October 15, 2020

RE: Black Forest Office – Rezoning Application – 1st Referral Comments - Resubmittal

Project Record Number: CC201

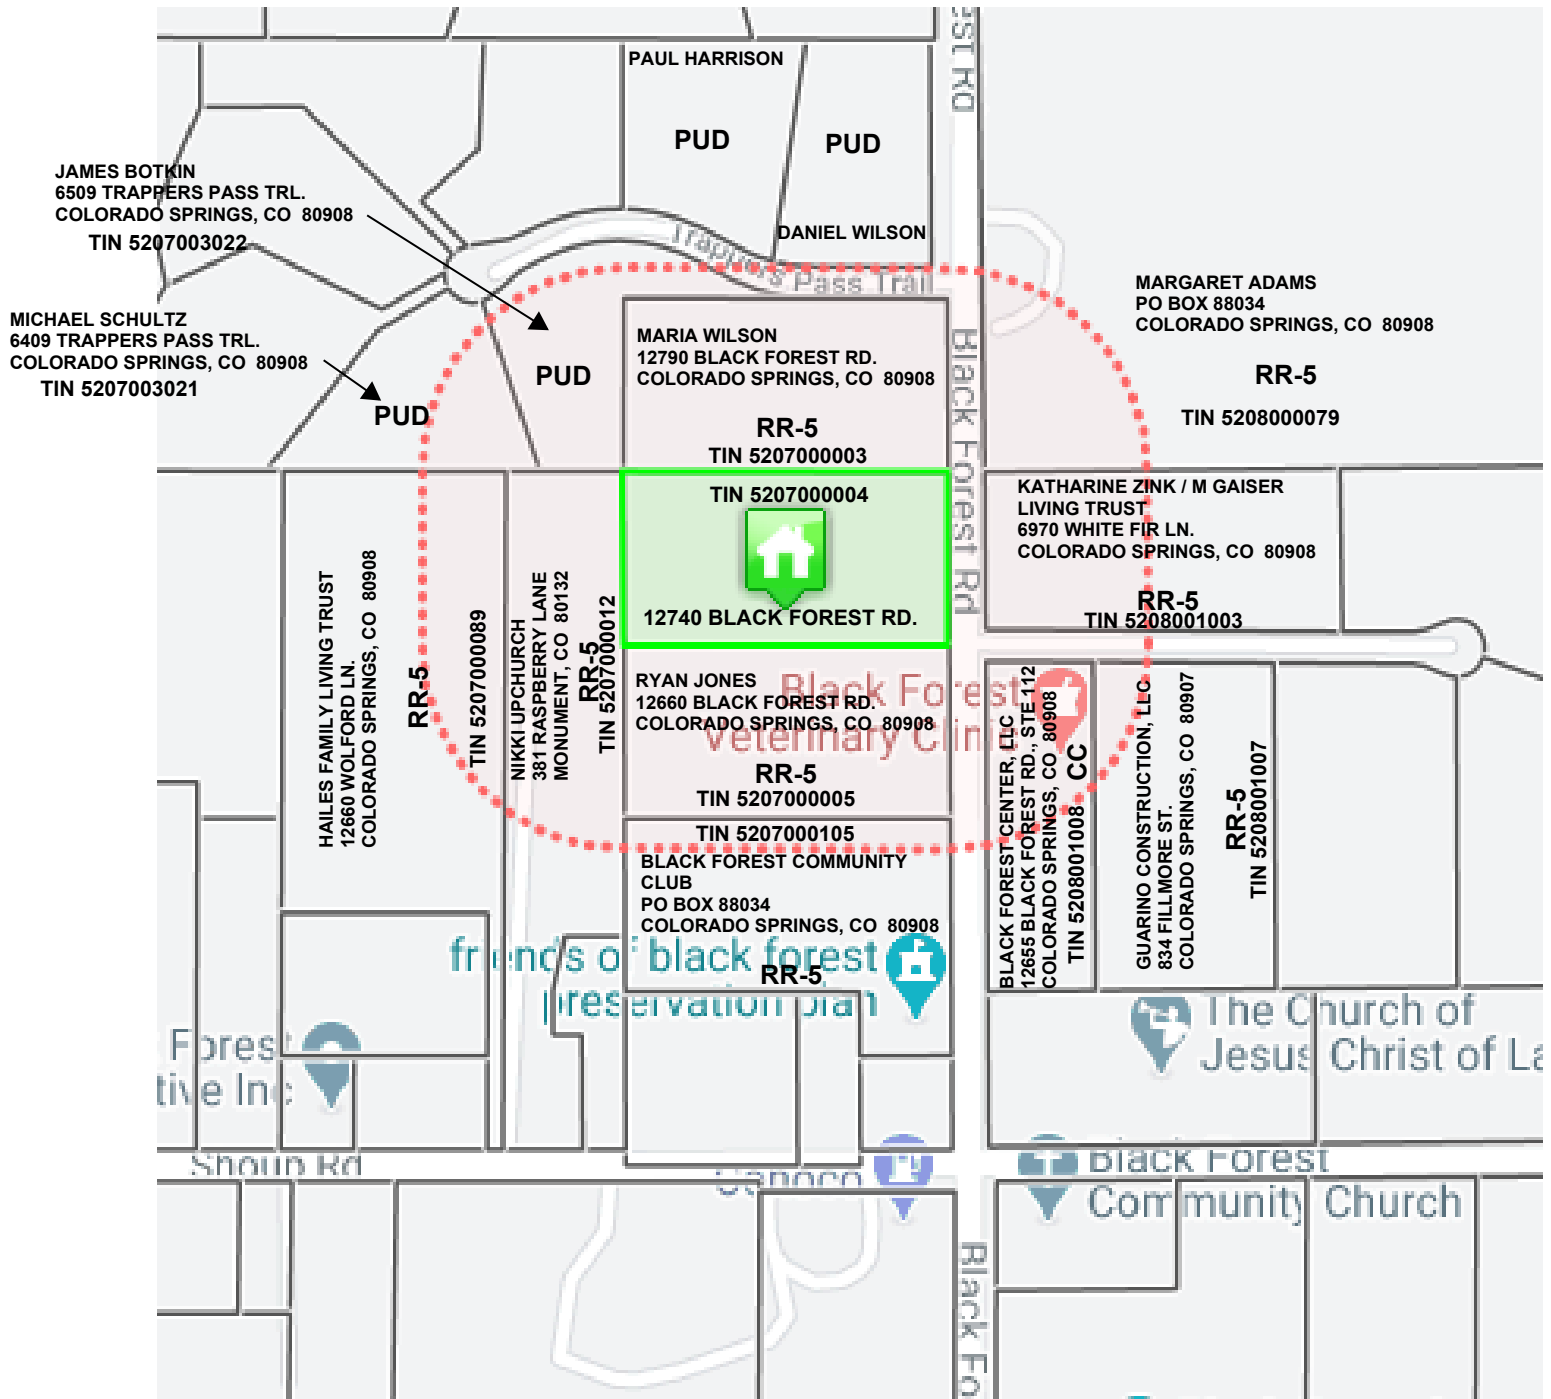
Vicinity Map Comment

11. A north arrow has been added to the Vicinity Map and included in this resubmittal.

# REZONE MAP

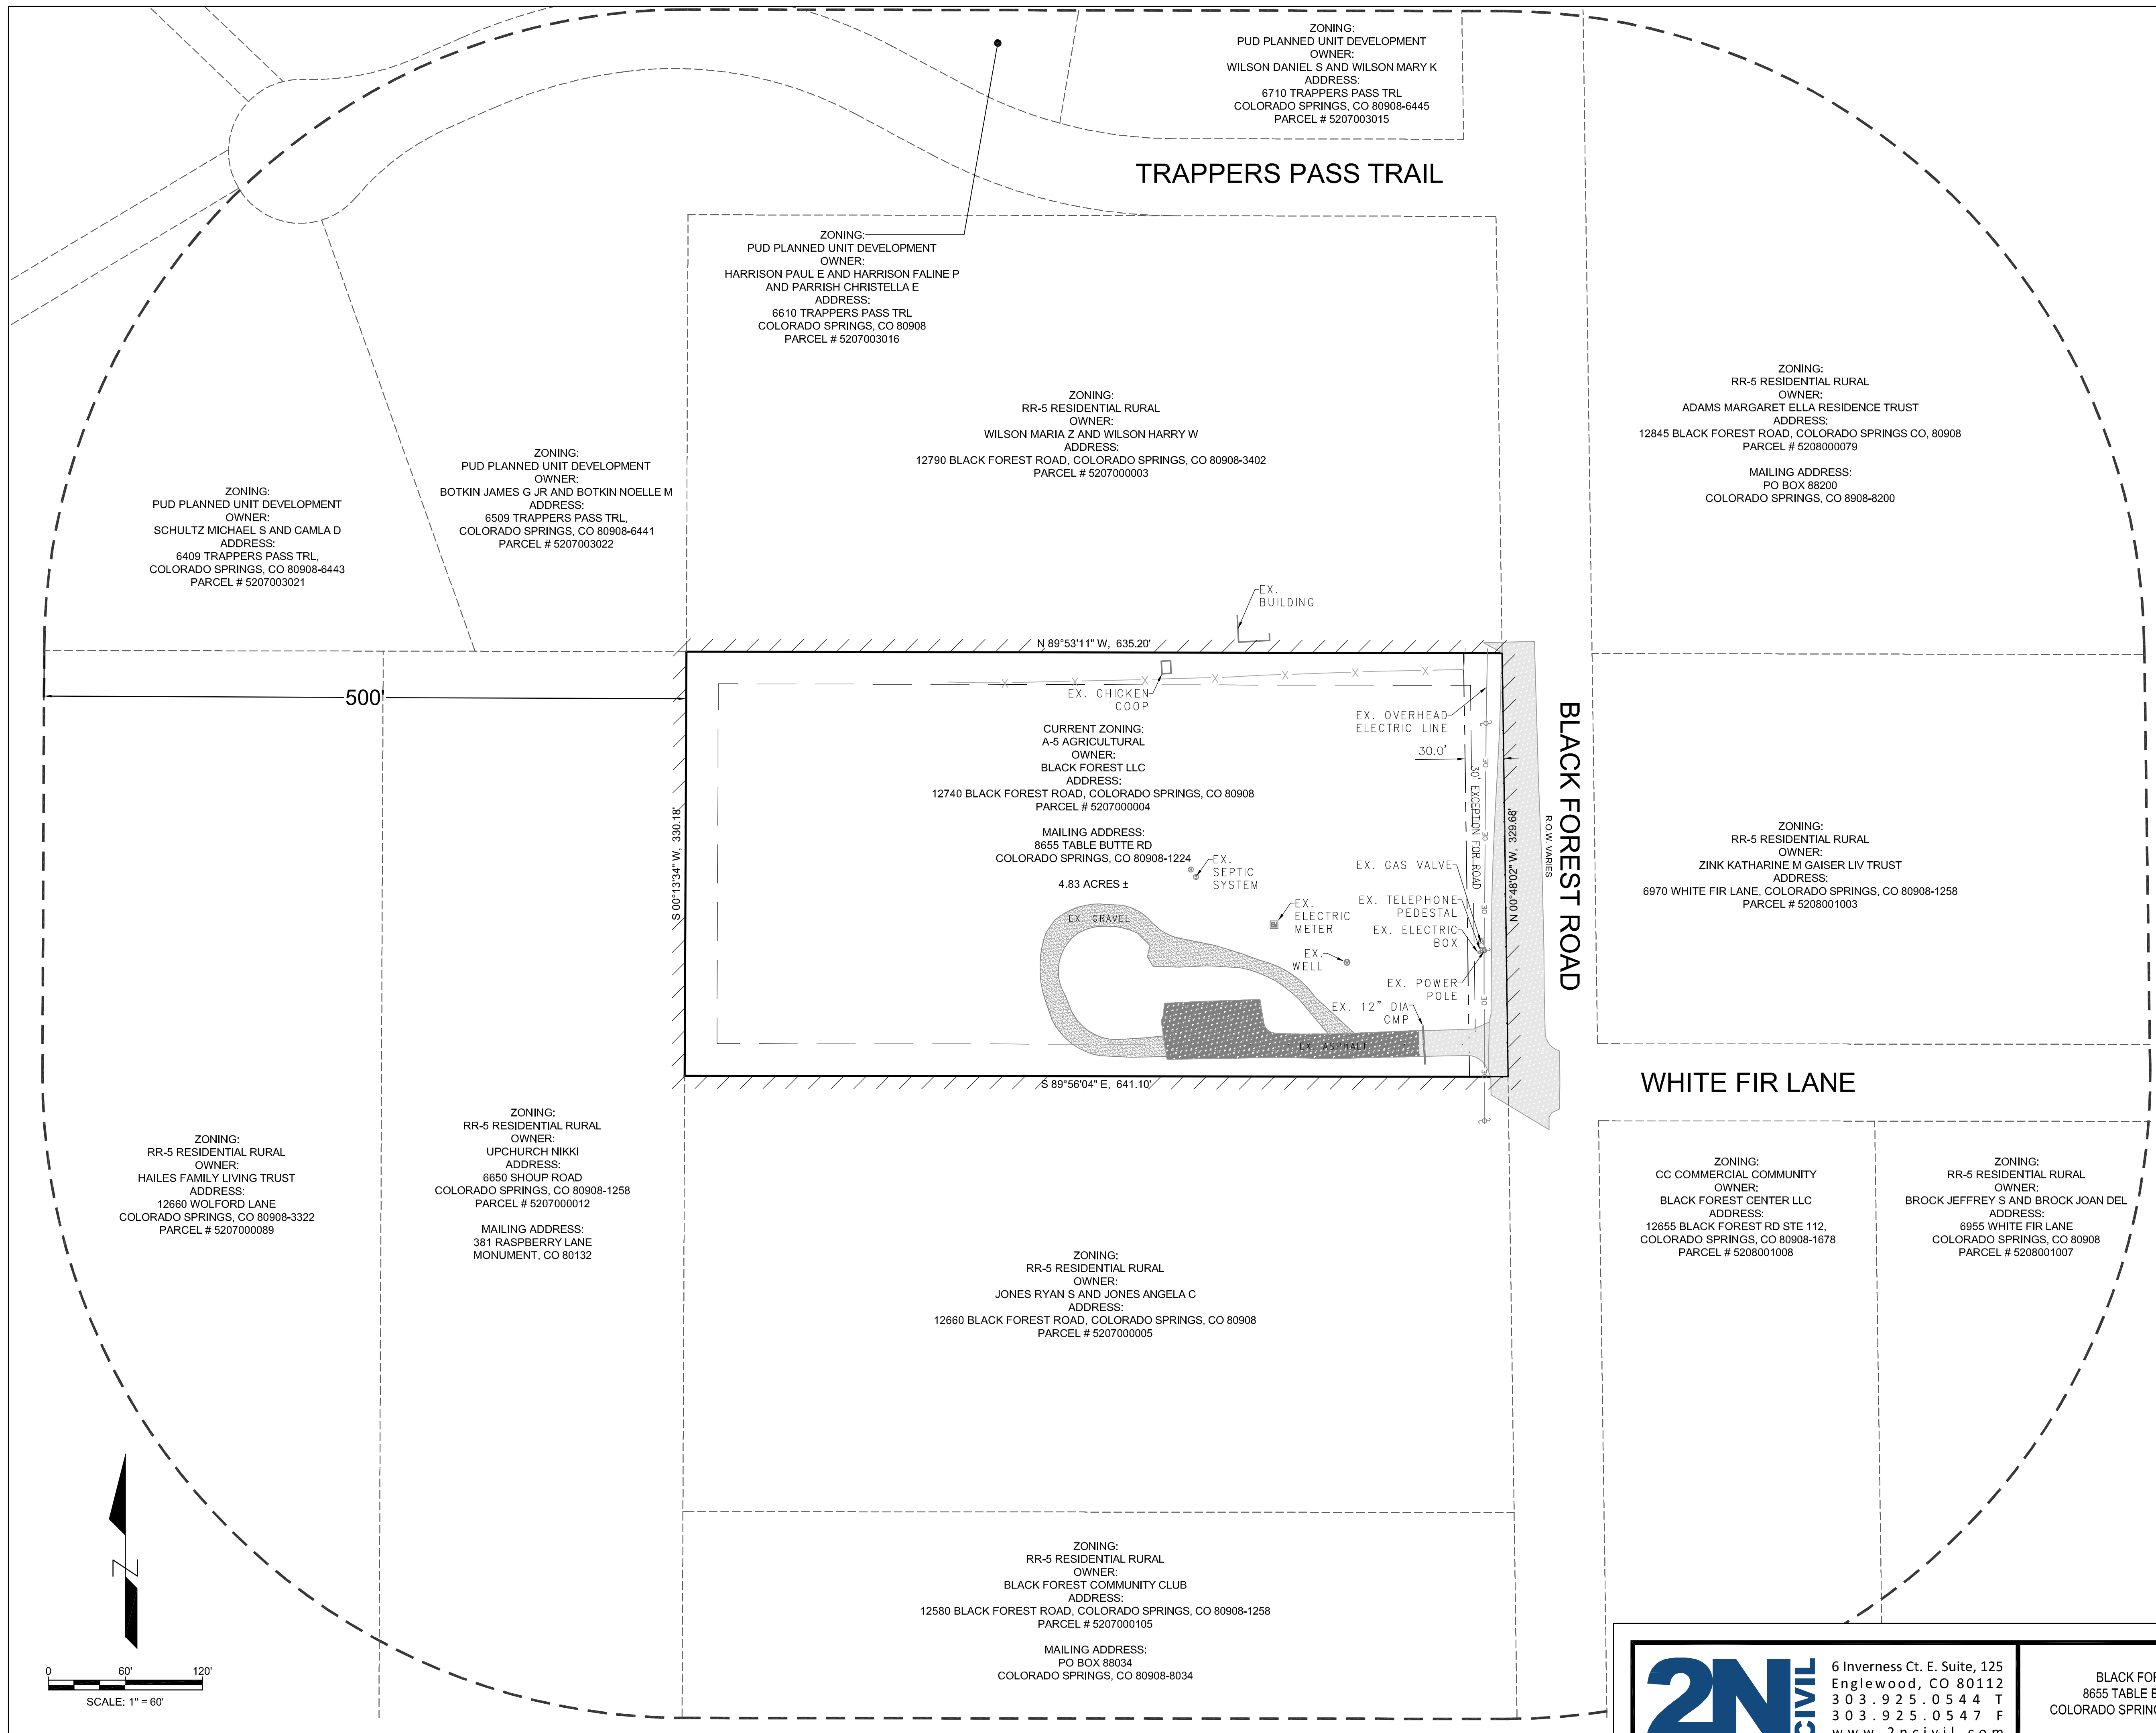
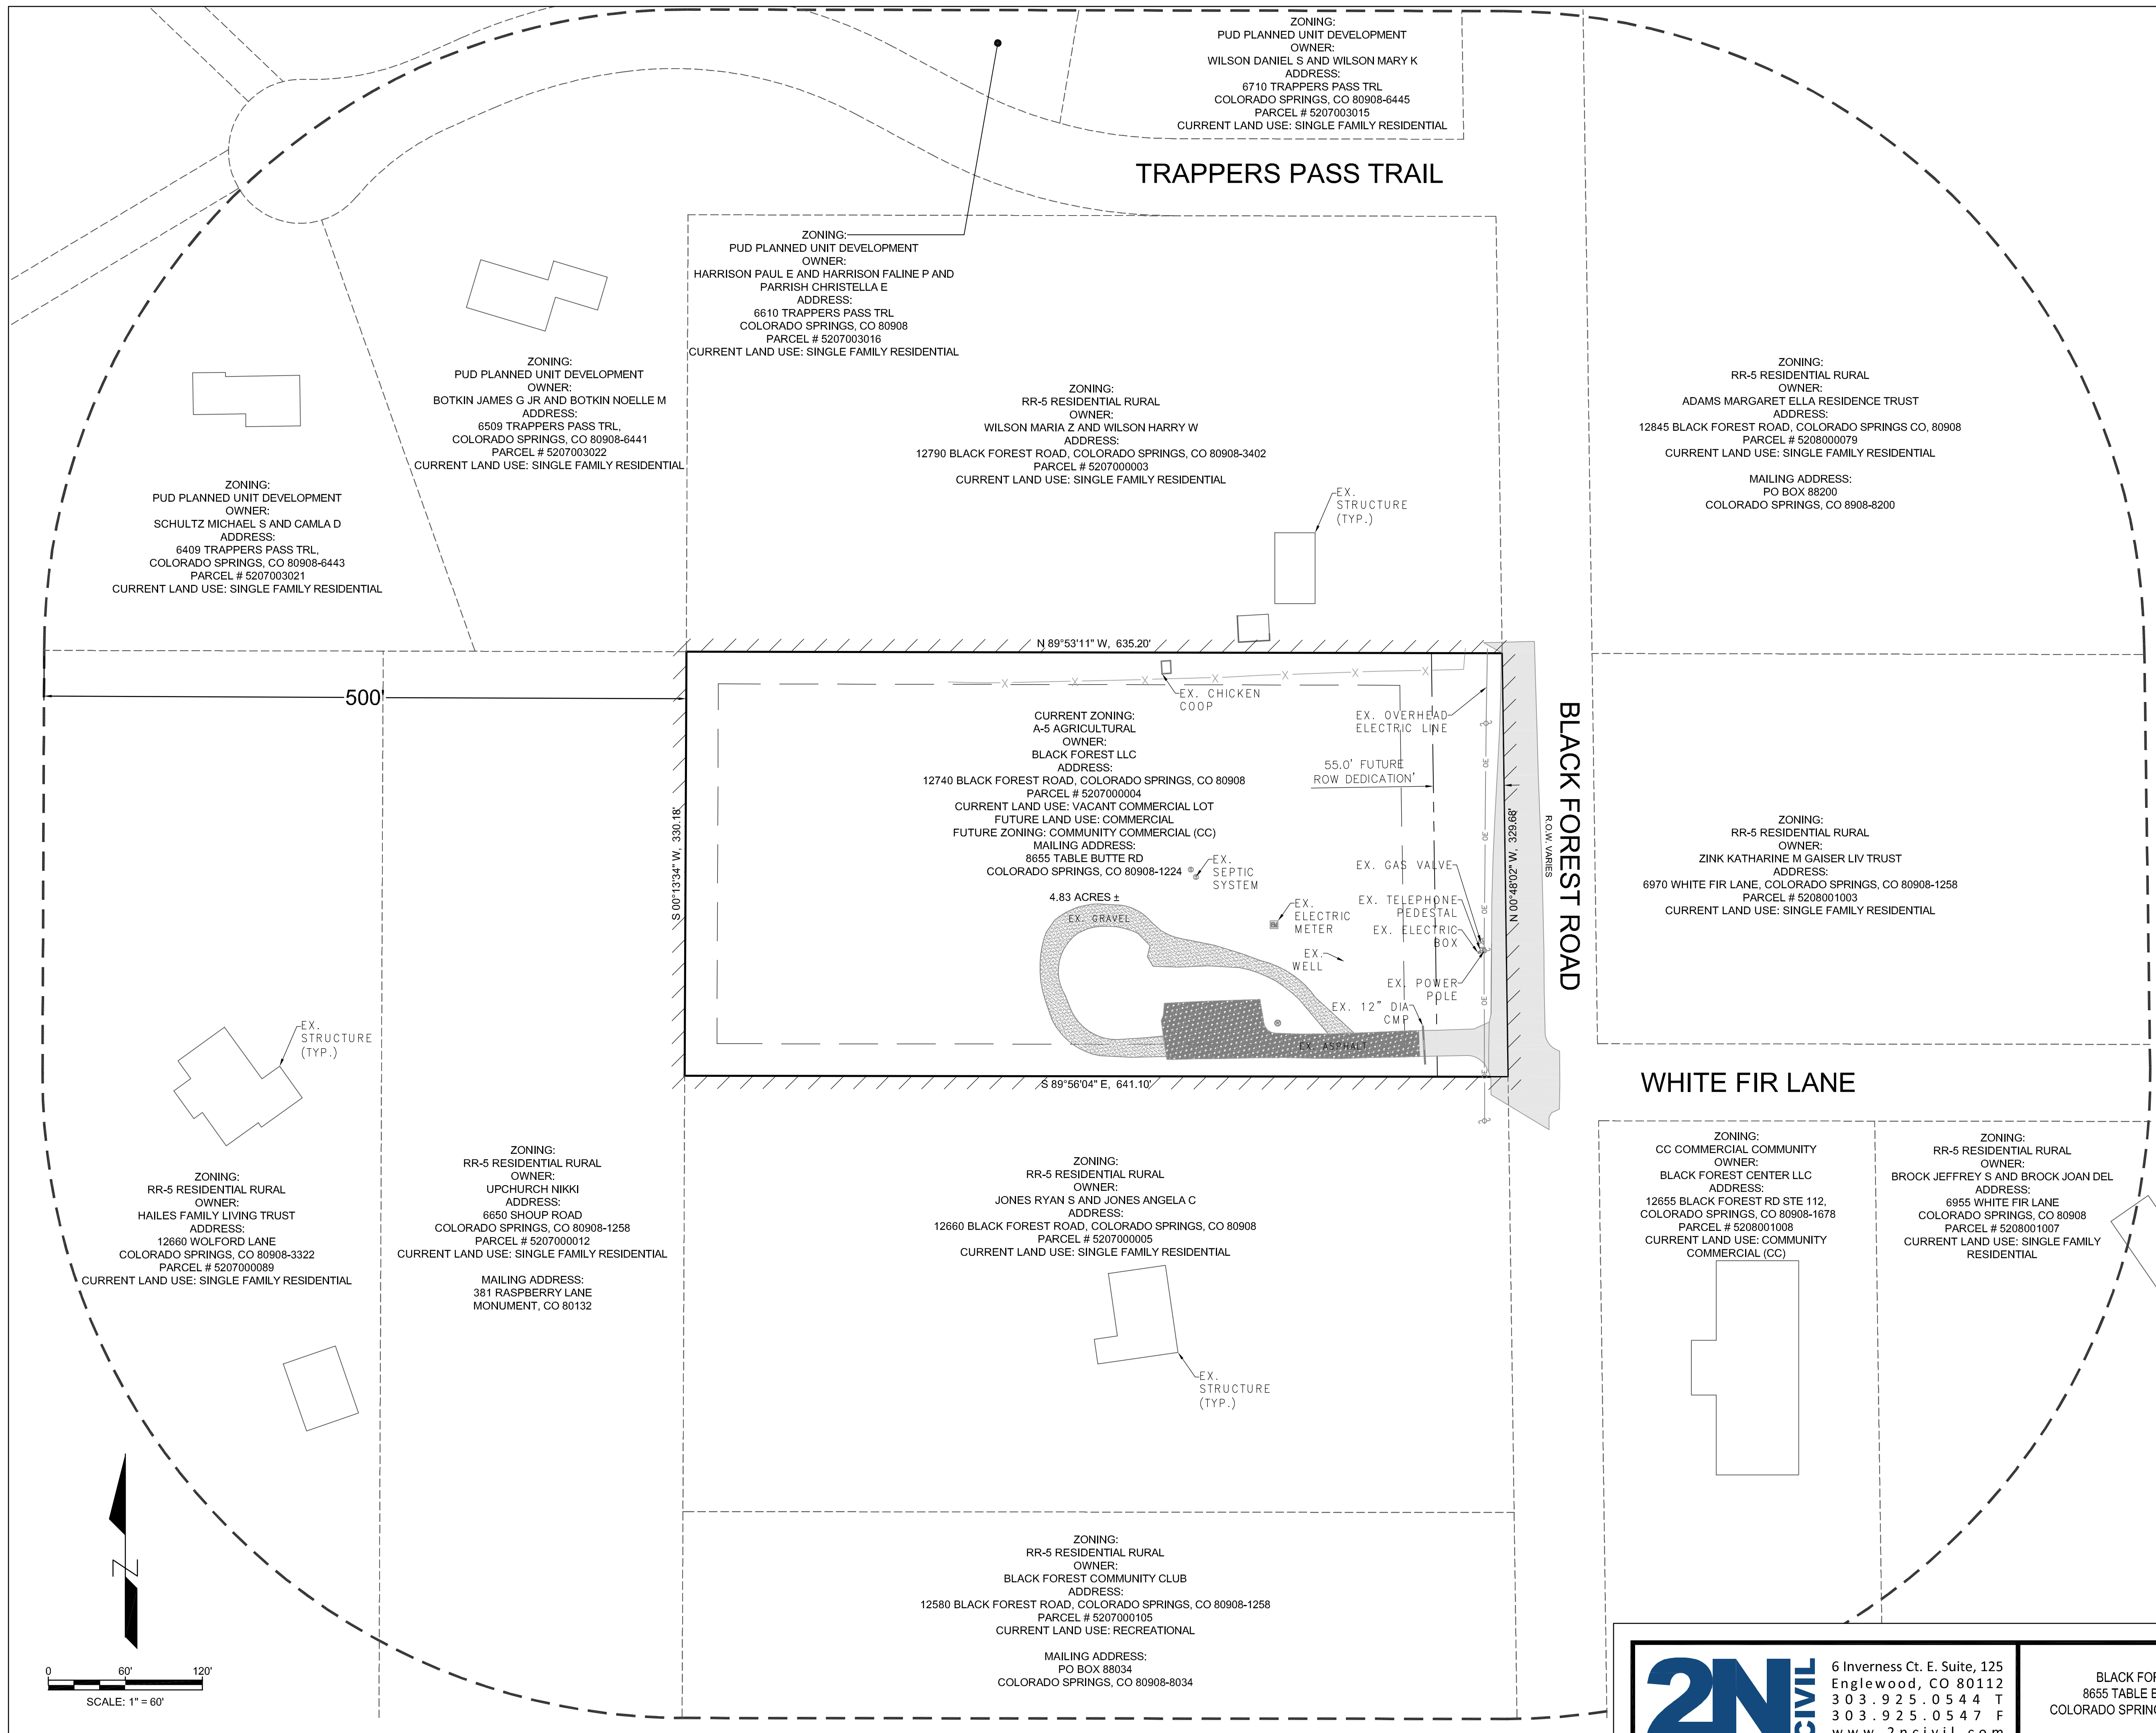
Rezone Map

8. The rezone map has been resubmitted to address staff comments.
